Your Ref: OWPC25688
Our Ref: K/32/19/PL 12-12-2019
Please ask for:
Mrs A Gardner

Demolition of existing dwelling and erection of 1 x three storey dwelling with swimming pool and associated amenity space and parking
Little Deerswood Gorse Avenue Kingston Gorse

Thank you for your internet representation made on 6th February 2020 which has been recorded as '**no objection**' with the comments as follows:

1703 SK121  
 Little Deerswood, Kingston Gorse  
 Ground Floor Plan  
 Scale 1:100

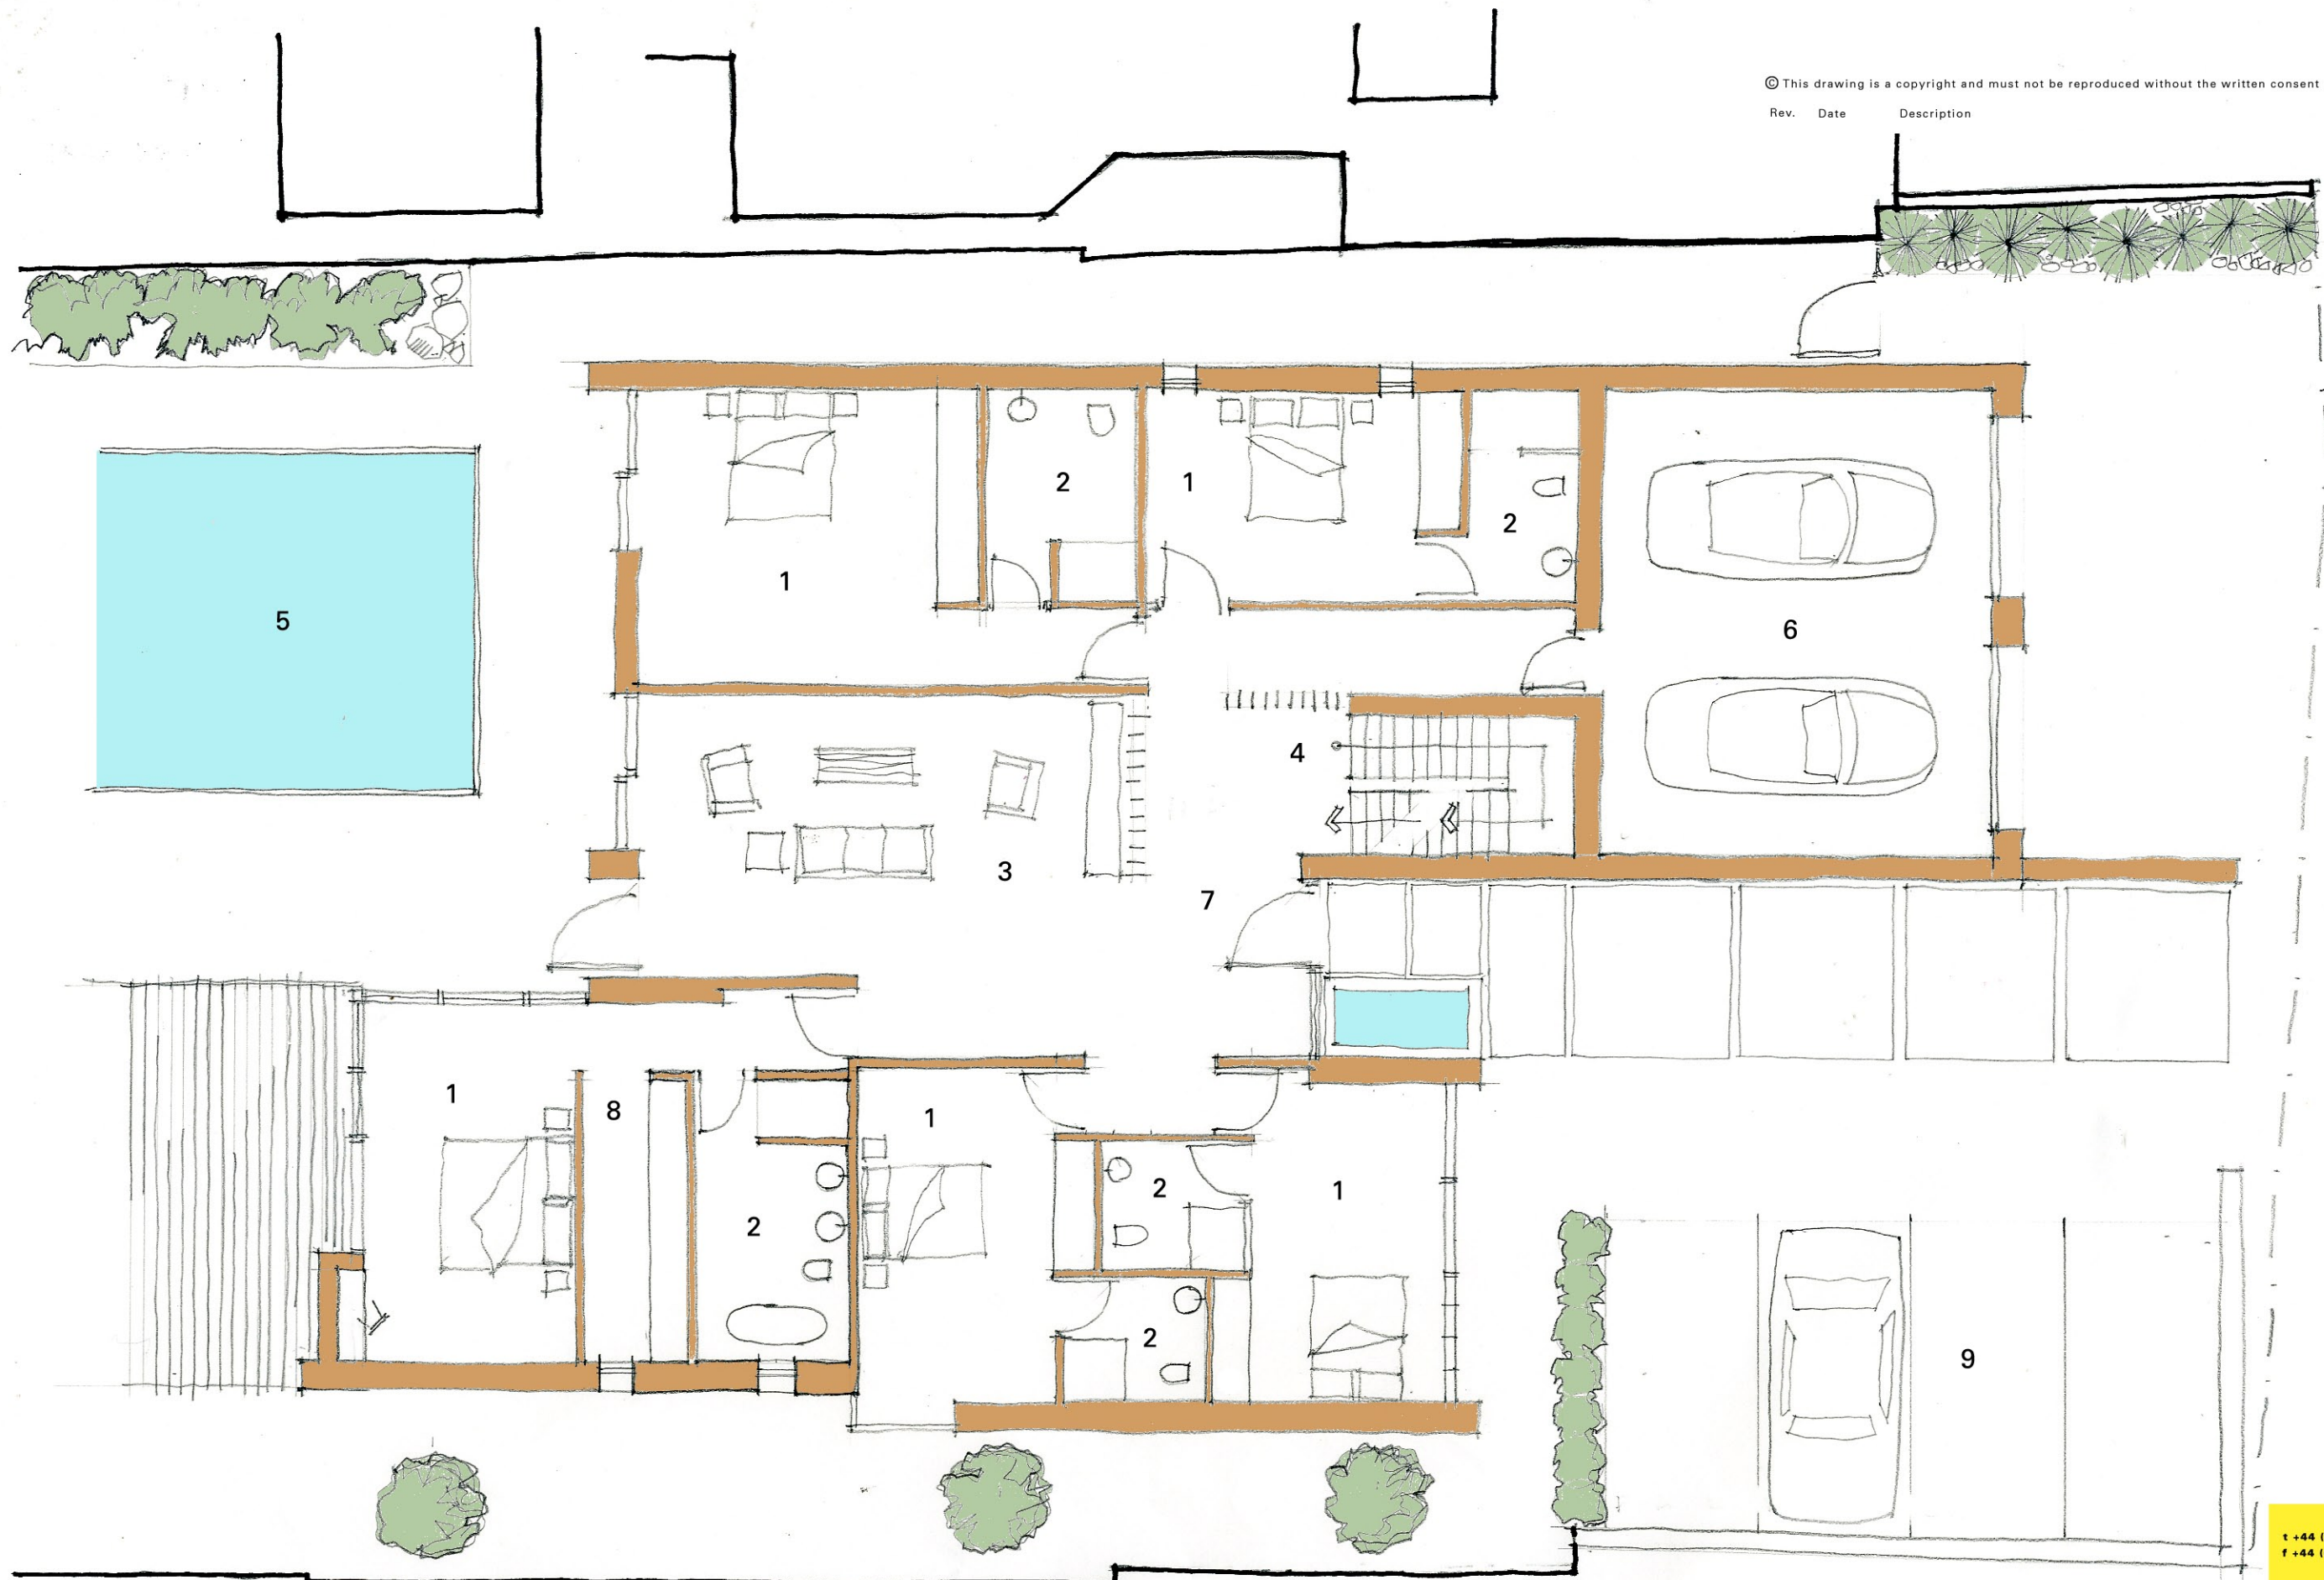
*We are in the process of purchasing White Lodge.
On the West elevation only the study is marked as opaque glass. The 3 Lounge windows should also be opaque given that it directly over looks White Lodge. This maybe an omission from the drawing. We request the pool house directly adjacent to White Lodge is noise insulated as it will be operating 24 hours a day.*
